Final Acceptance (FA) Punchlist
EPC - DPW - Stormwater Section

Project Name:	Lorson Ranch East F1
EDARP Filing Number(s):	SF188, CON1958
ESQCP Number:	ESQ182
Attendees:	DPW SW: Natasha Grimaldo Developer: N/A
Date of Walk-Thru:	11-13-2023
Walk-Thru Number:	4 th

SHEET NUMBER  
C9.2

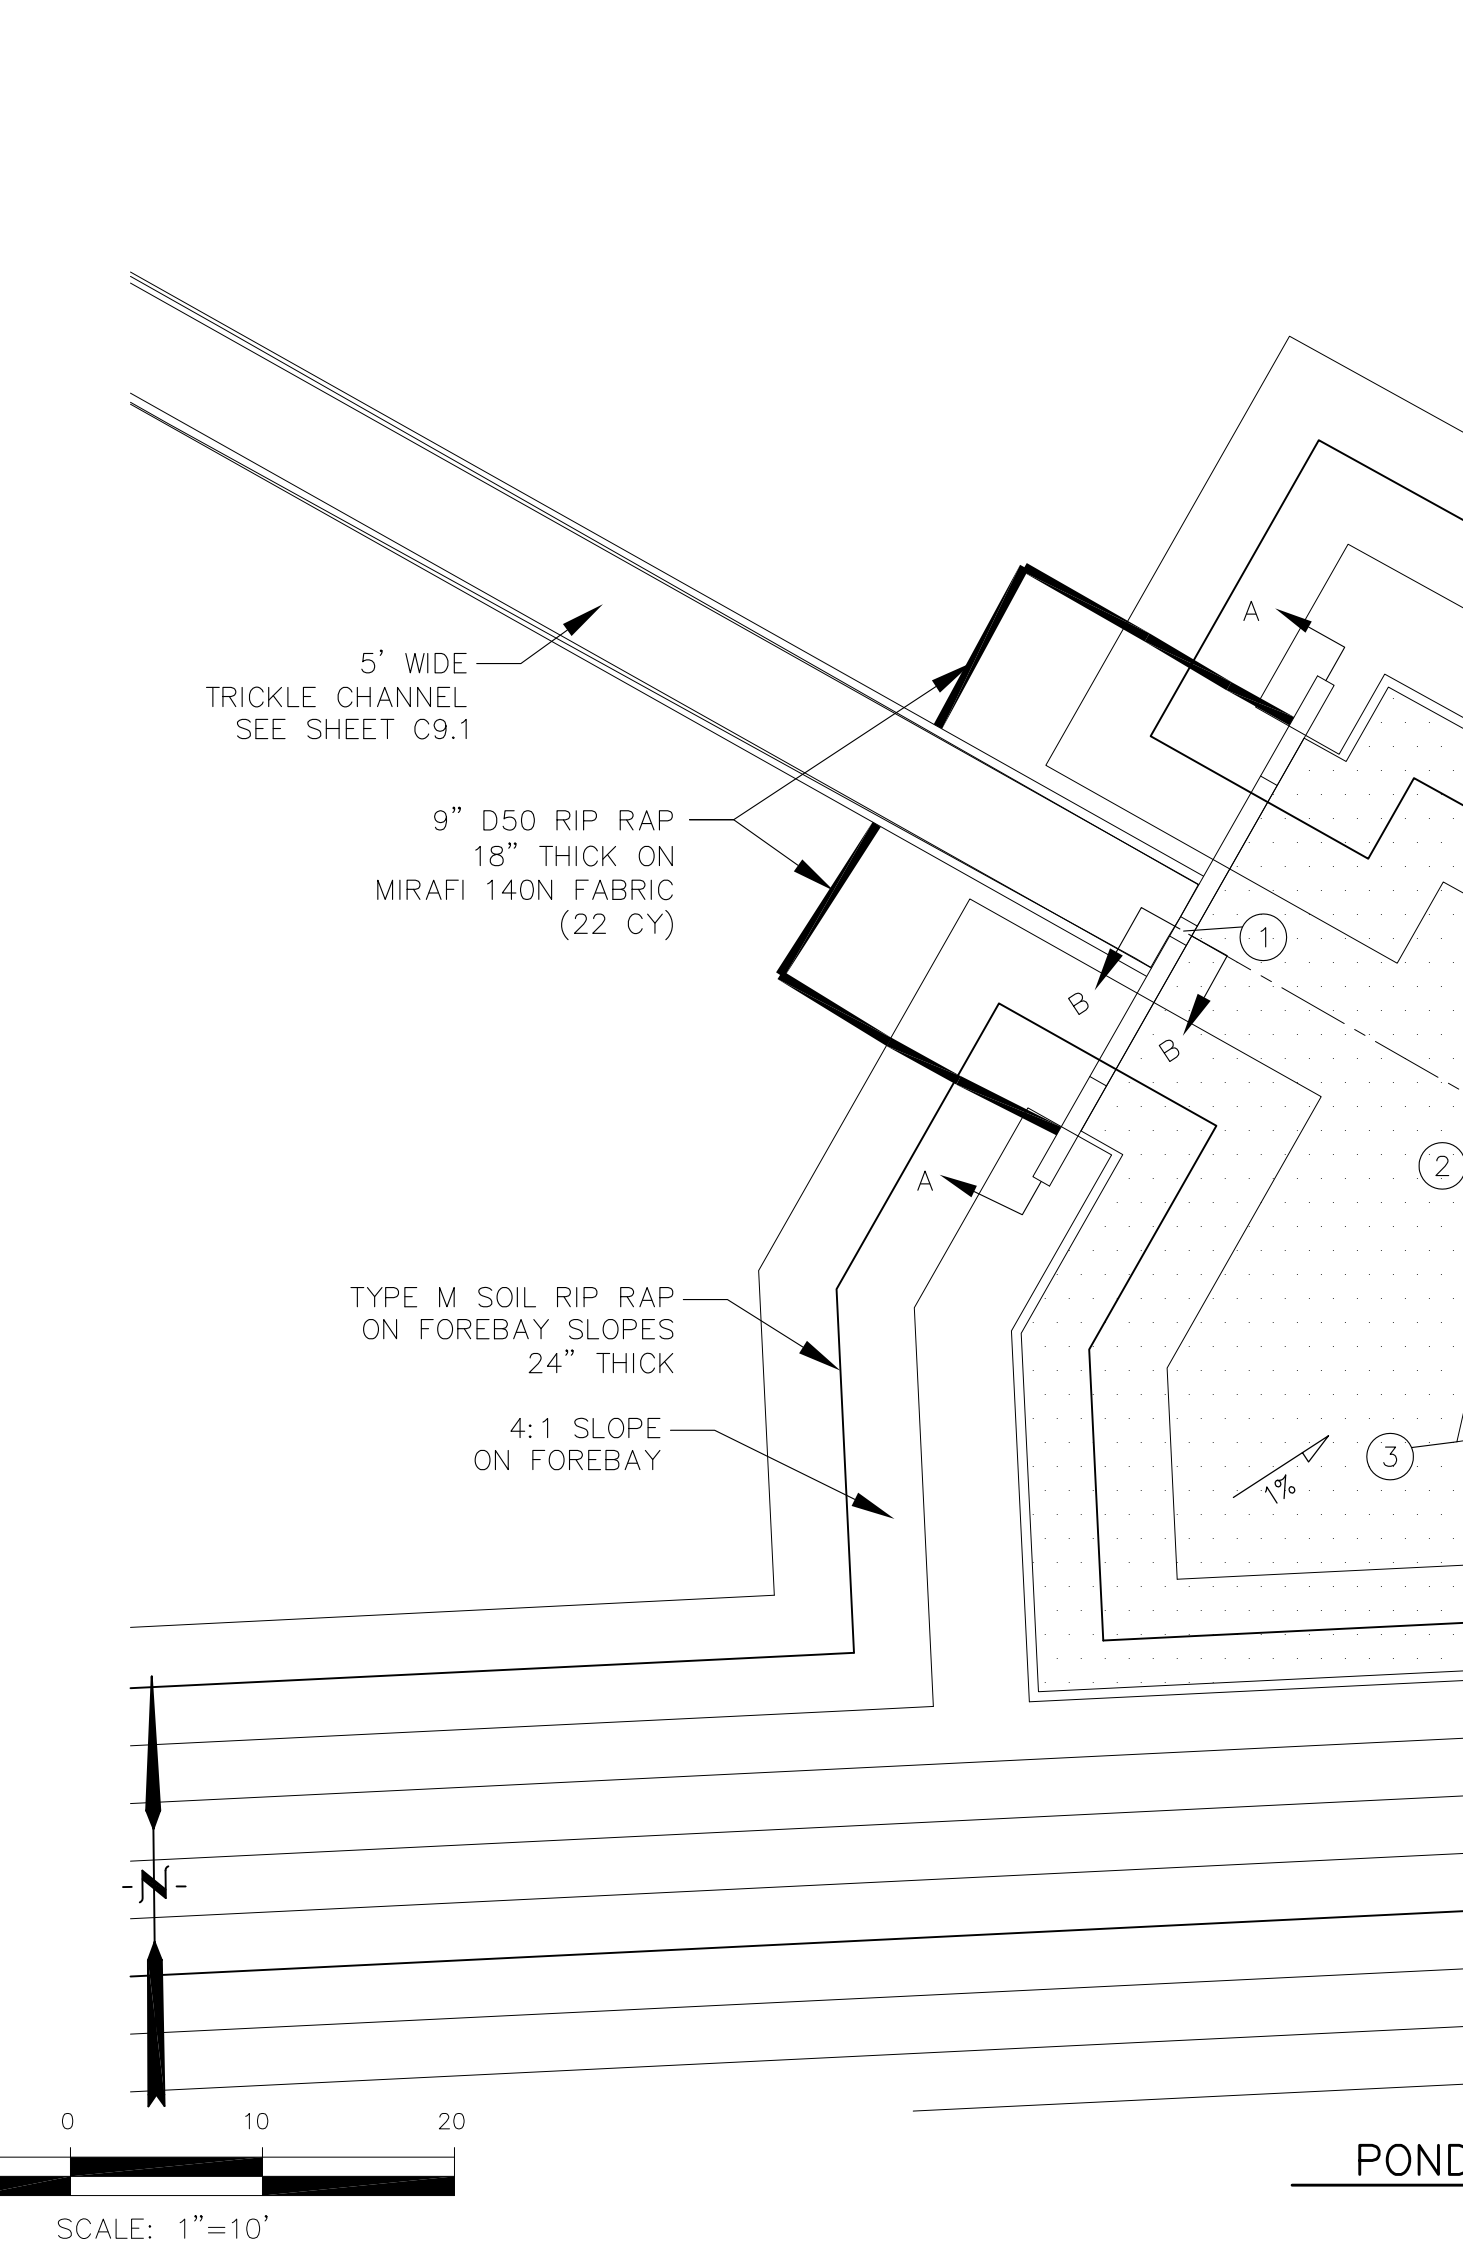
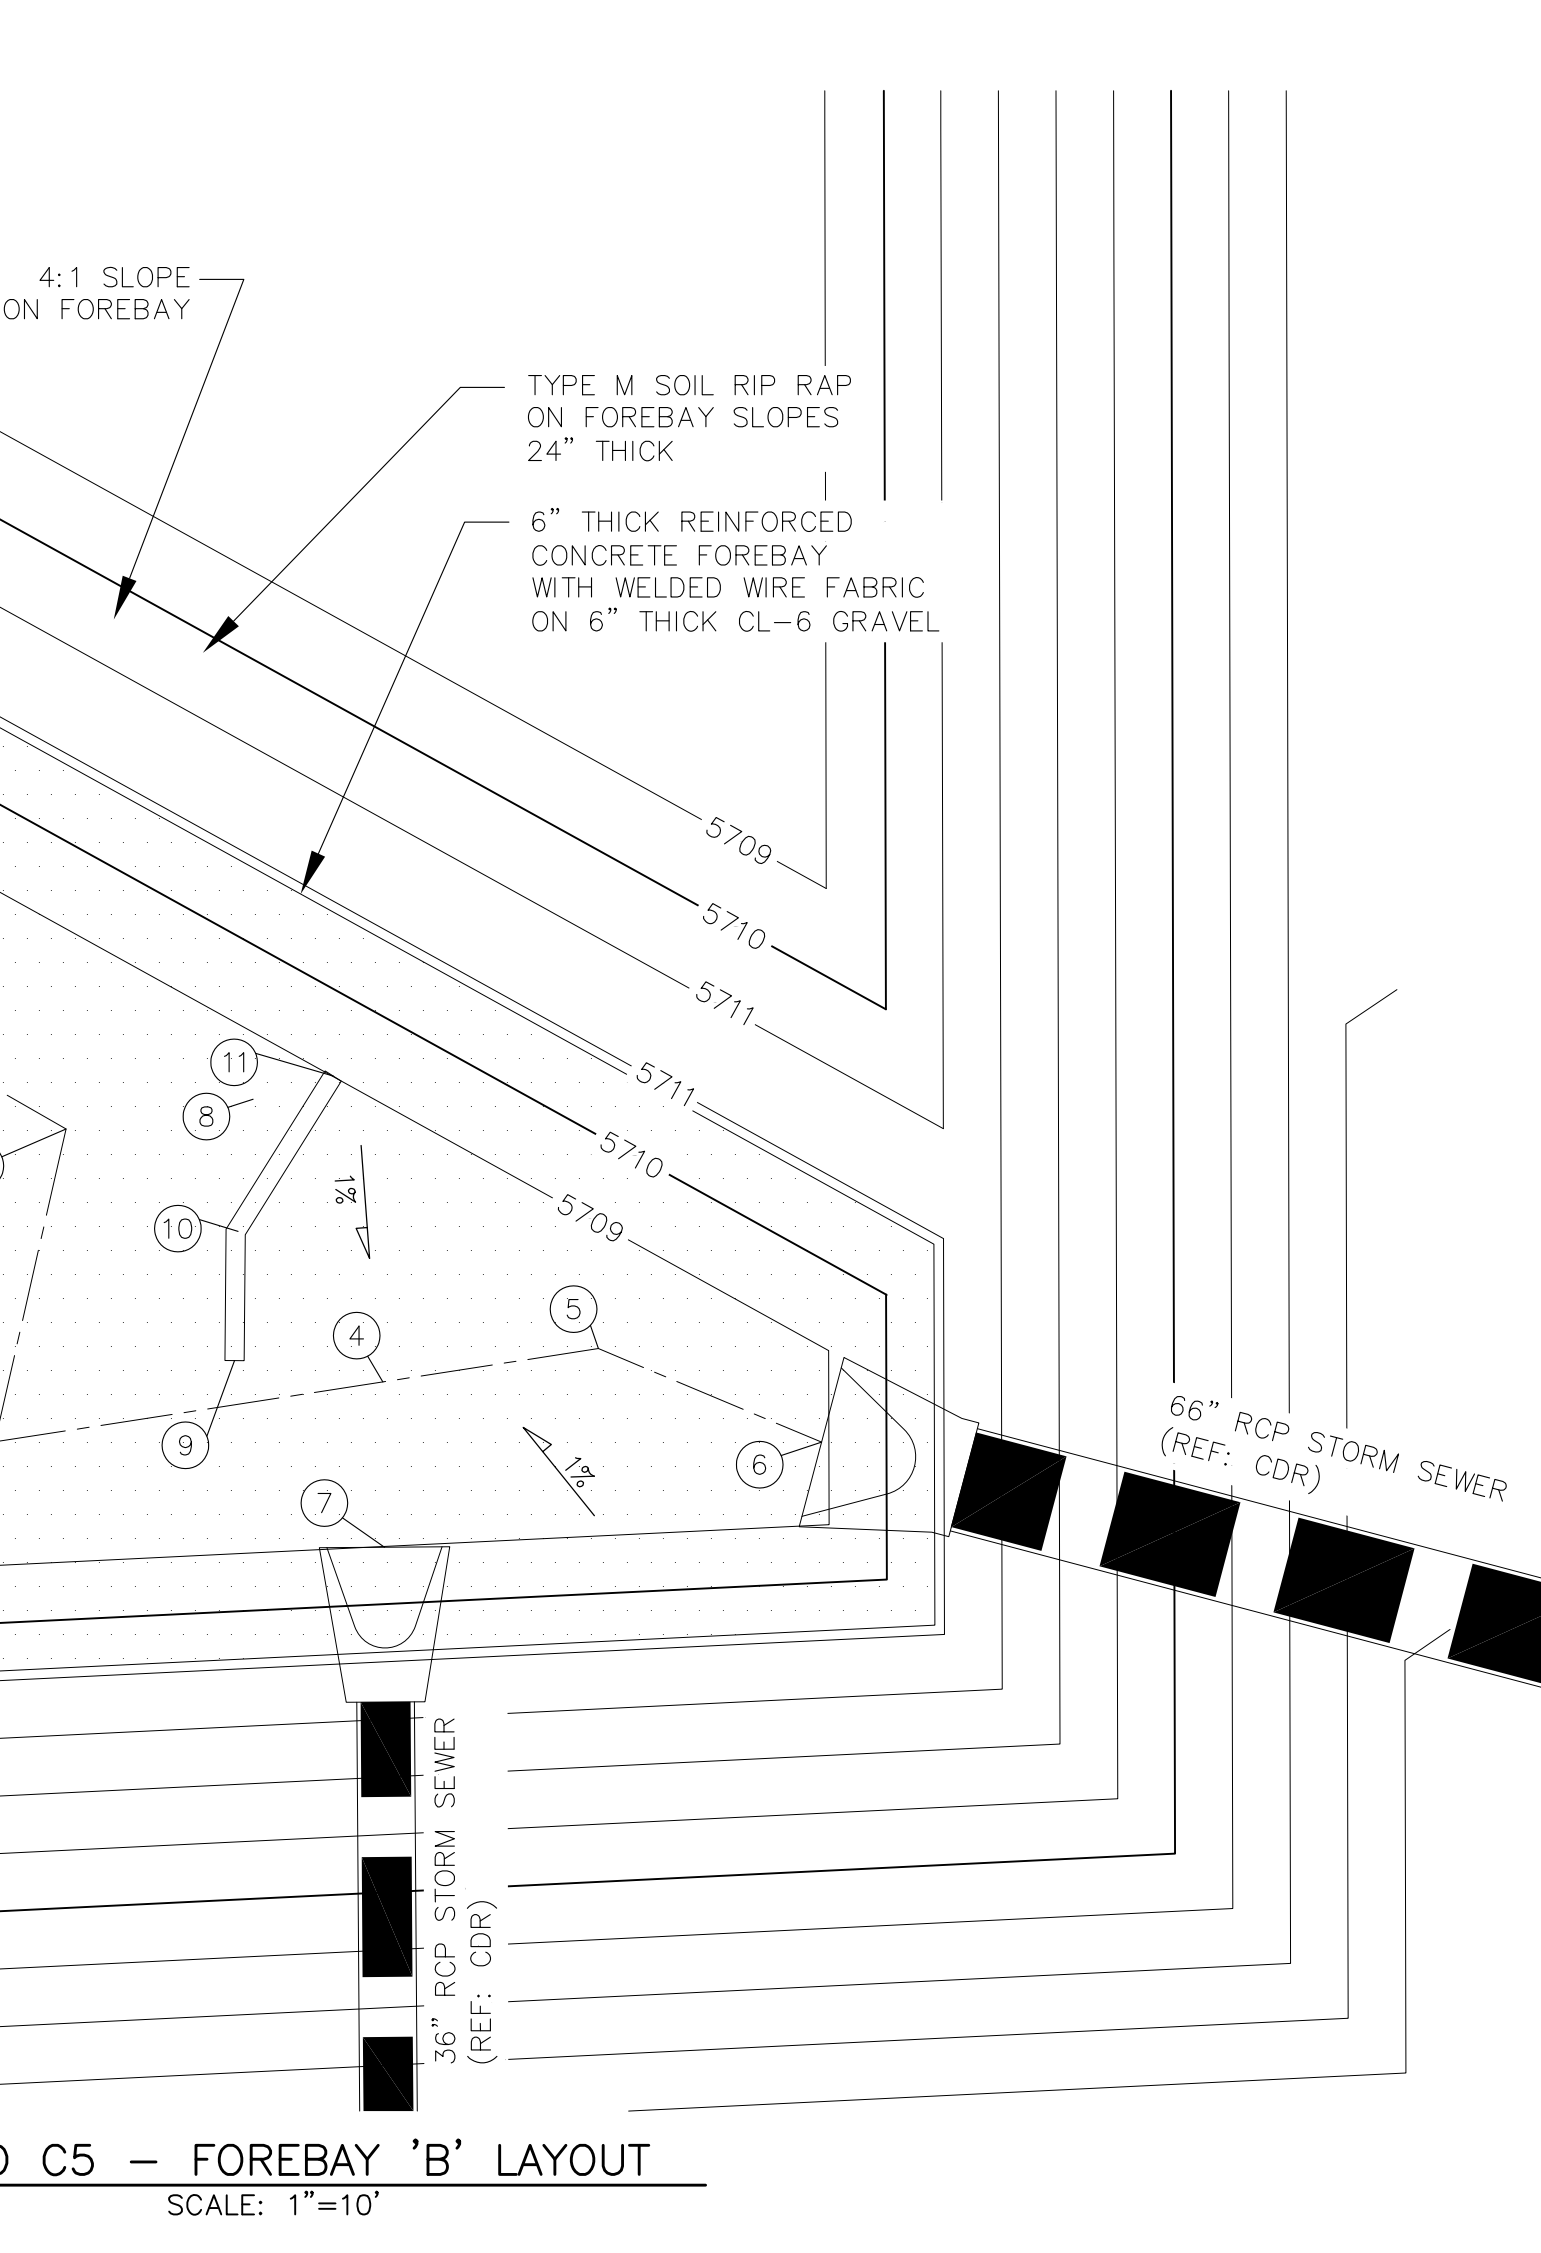
- Repair cracks in forebays and trickle channels.
- Remove sediment and debris from outlet pipe.
- Remove rock sock from forebay notch in forebay B.
- Implement 9" D50 soil rip rap per specification on forebay A and B. Reference sheet C9.2 of CDs (or show engineered approved deviation on As-builts).
